# Submission in regard to the “Modification 4 - CBD and South East Light Rail Project”

## Cyclist Access

With regard to section ‘**2.4.2 Cyclists**’, and its proposal to use Arthur street between Belmore and Wansey Rd as a cyclist access route:

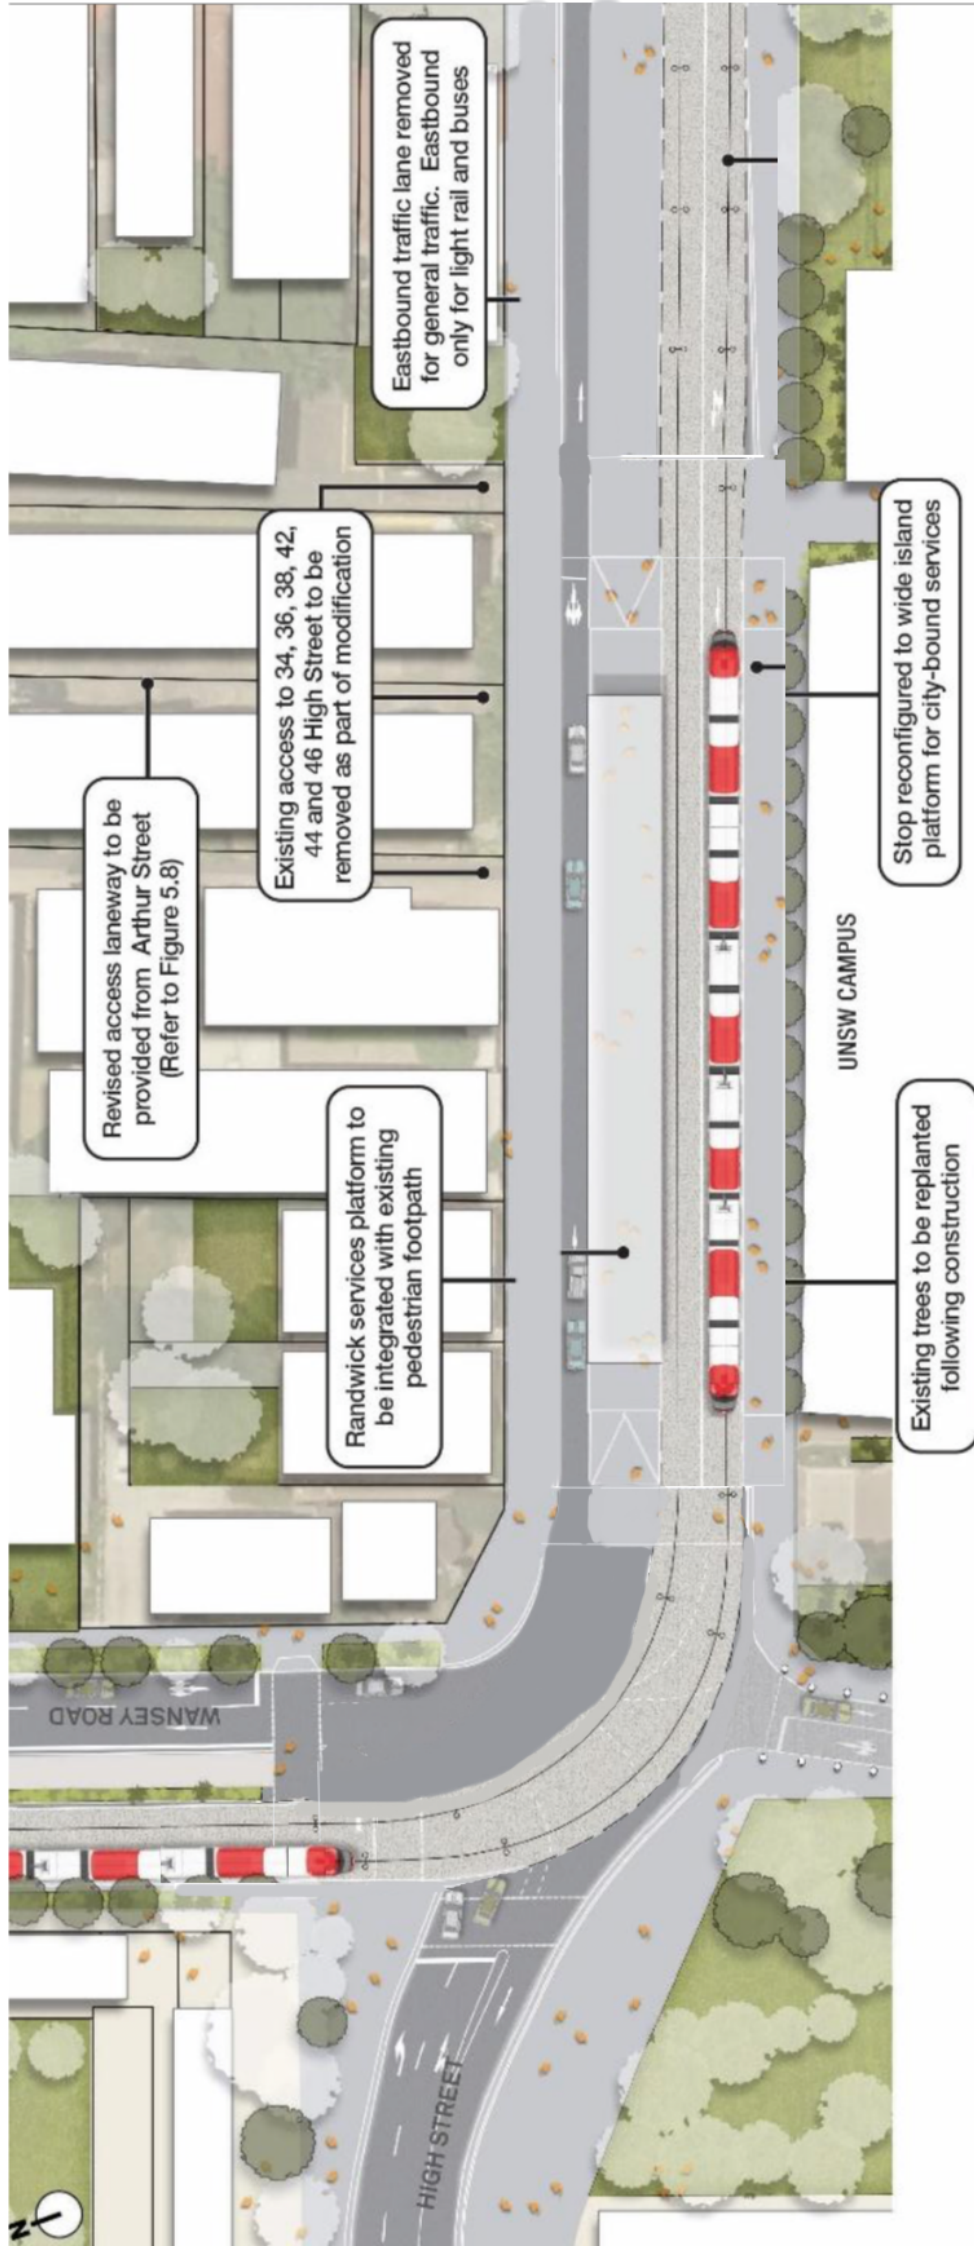
- The removal of cyclist access along the top of high street forces cyclists along the congested start of Belmore road and in direct competition at lights with vehicles also entering Belmore road from Avoca street, and also currently the North-bound bus stop and pedestrian crossing next to Arthur street.

- The proposed north-bound morning peak hour bus zone would add additional pressure to cyclists having to make their way into Belmore road.
- The proposed use of Arthur Street as a cycle way forces cyclists directly across the busy and dangerous non-traffic-controlled intersection with Botany Street. The proposal for traffic lights at this intersection would thus become a 'must' if cyclists are to use it.

- Allow cyclists to continue to use the full length of High-street as an access route between Avoca Street and UNSW. The opportunity exists to provide cyclists with the safety of an additional purpose-allocated route along this stretch of road, including from the Avoca street intersection.
